**Your Ref: 2025/91184**

**Our Ref: A/01971**

**6th March 2026**

**Land Off Bretton Street, Savile Town, Dewsbury - (KIRK) Erection of two storey industrial unit (Use Class E(g)(iii)), with associated car park, service area and other associated works**

| DRAWING No. | KS826 / D01 | | | REV. | P1 |

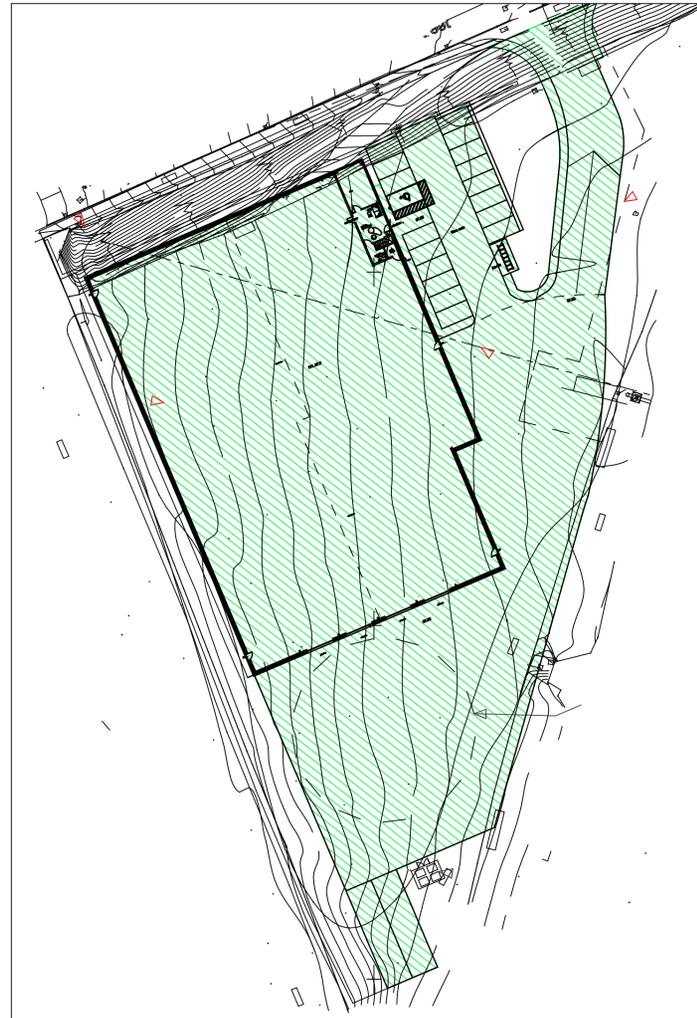
**The development shall be carried out in accordance with the details shown on the submitted plan, KS826/D01 (revision P2) dated 27/10/2025 that has been prepared by Krypton Structures, unless otherwise agreed in writing with the Local Planning Authority. (In the interest of satisfactory and sustainable drainage)**

- a) The proposed sewer diversion (subject to the requirements of Section 185 Water Industry Act 1991).
- b) The proposed building stand-off from public sewer centre-line (of five metres)
- c) The proposed separate systems of drainage on site with combined off-site
- d) The submitted drawing shows surface water proposed to be drained to the Calder and Hebble Navigation
- e) The submitted drawing shows foul water proposed to be treated before discharging to the Calder and Hebble Navigation

submitted on drawing KS826/D01 (revision P2) dated 27/10/2025 that has been prepared by Krypton Structures.
